Our Ref: LU/233/14/NMA
Your Ref:

Application for A Non-material Amendment Following a Grant of Planning Permission

Development Application for a non-material amendment following planning permission
LU/115/14/HH - relating to raising the decking area

Location 36 Clun Road Littlehampton

DRAWING NO:	REVISION:
1043/1	A

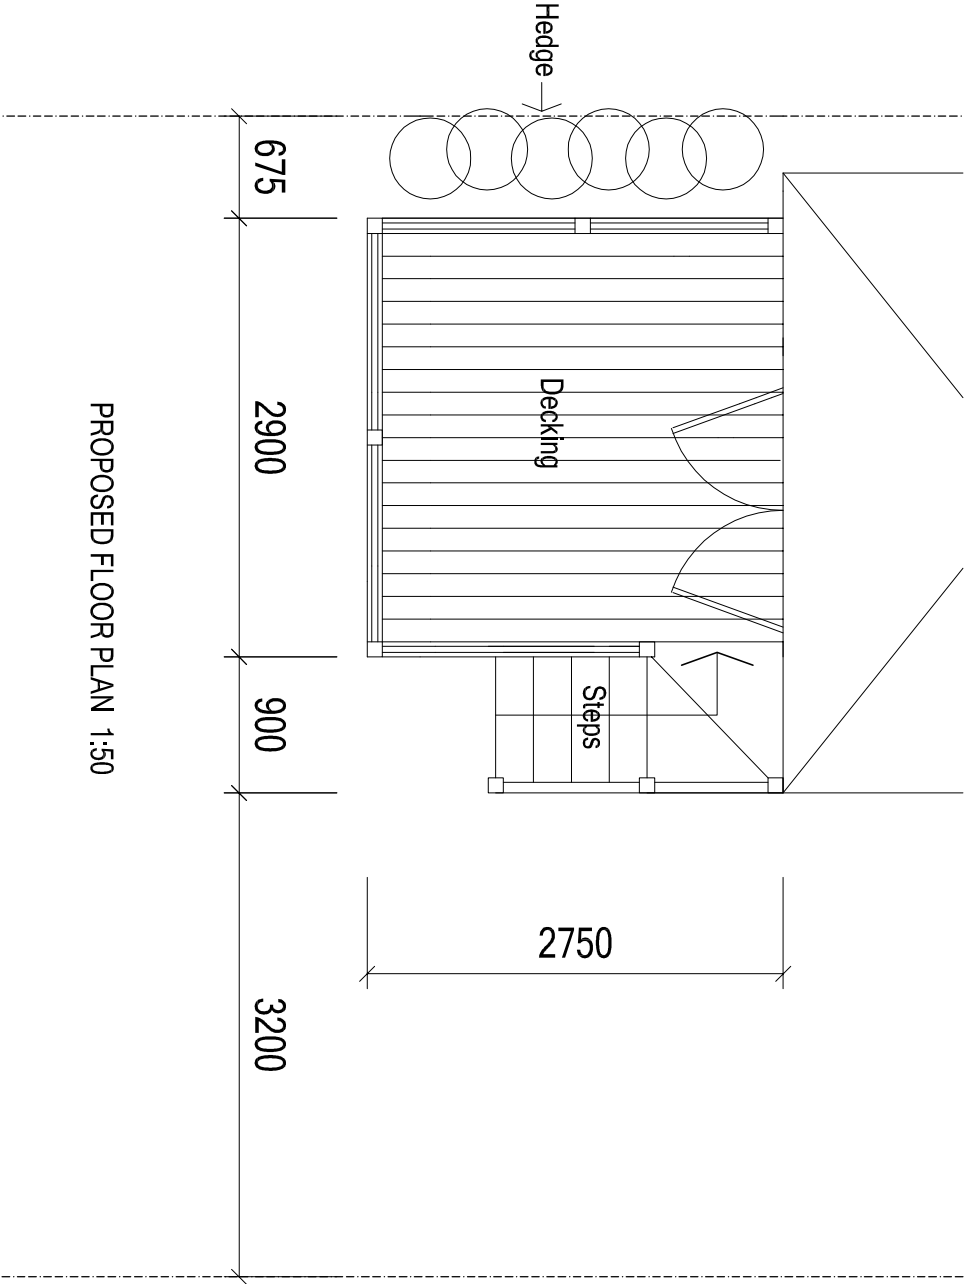
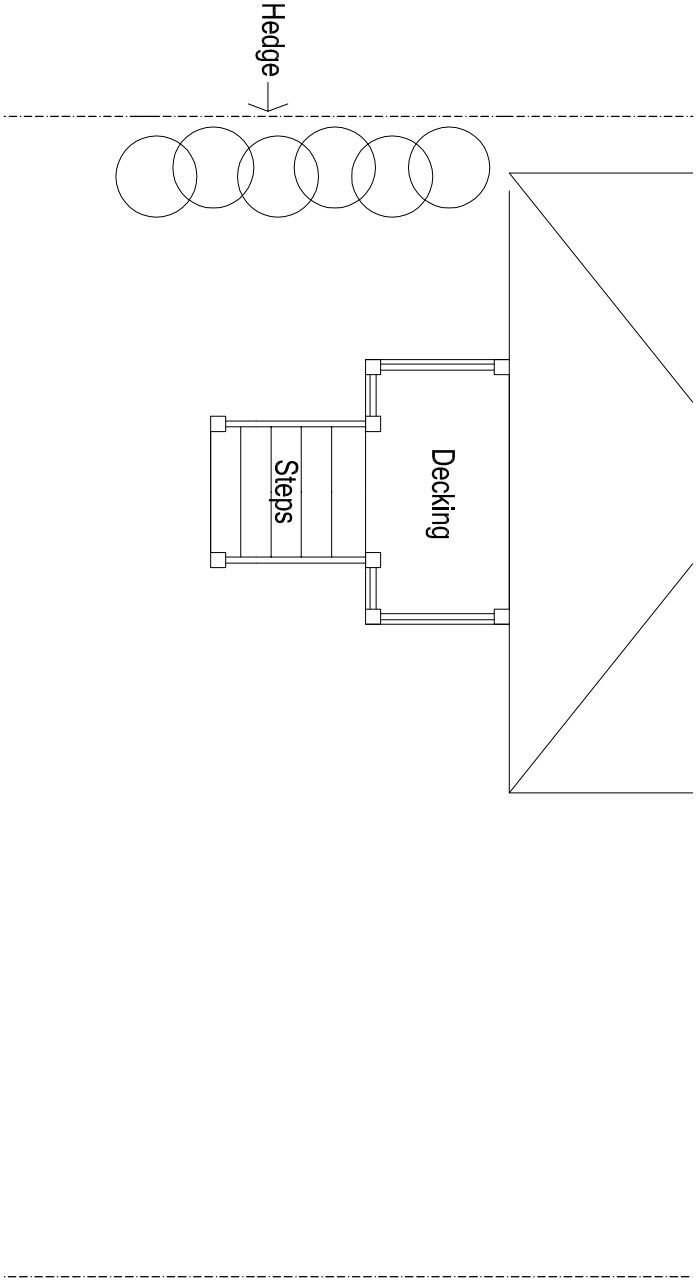
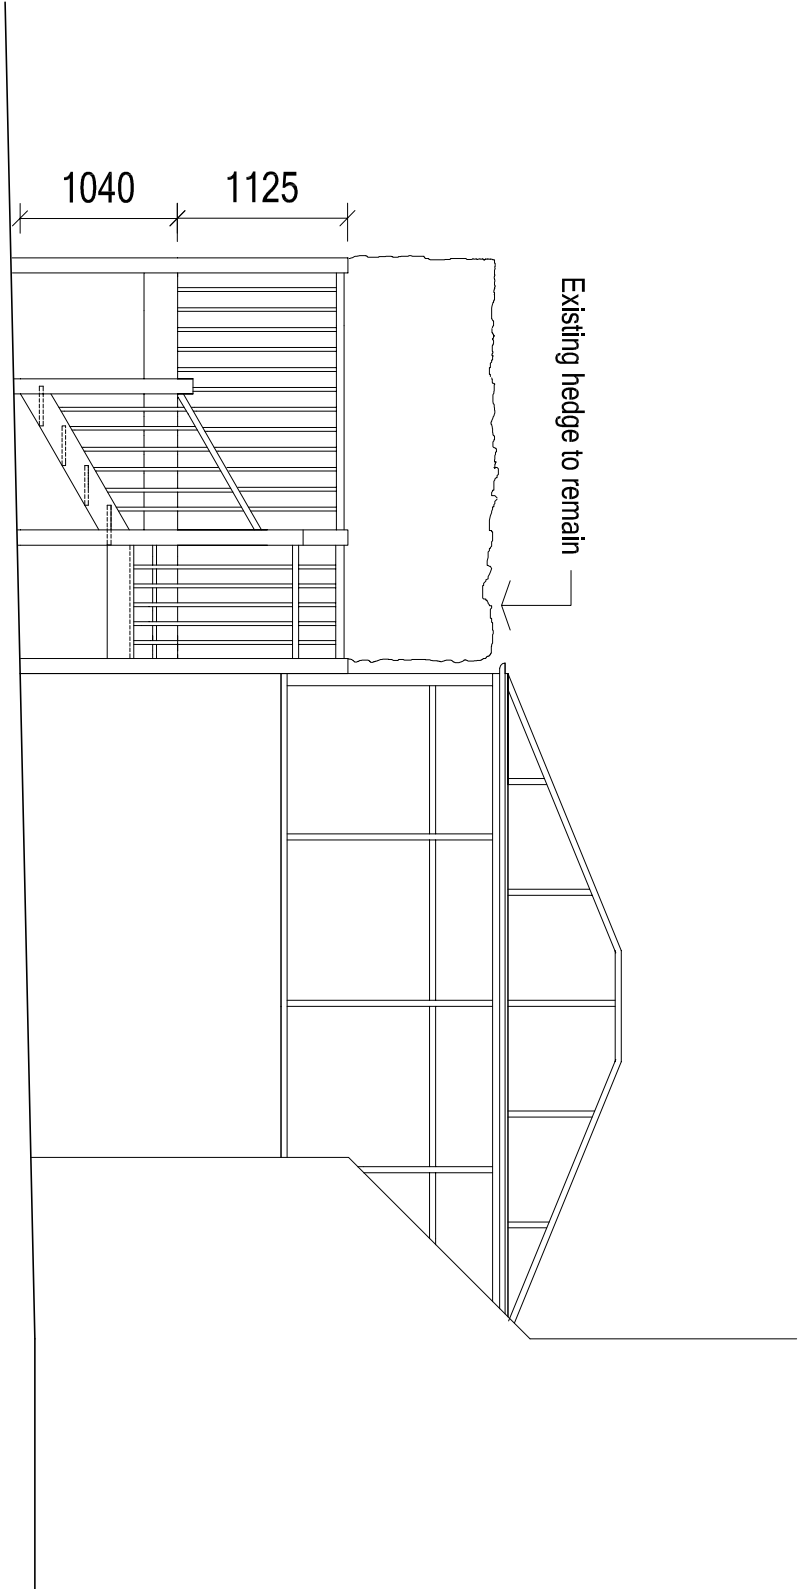
Please amend drawing No.1043/1 rev A with the existing and remaining hedge clearly indicated.
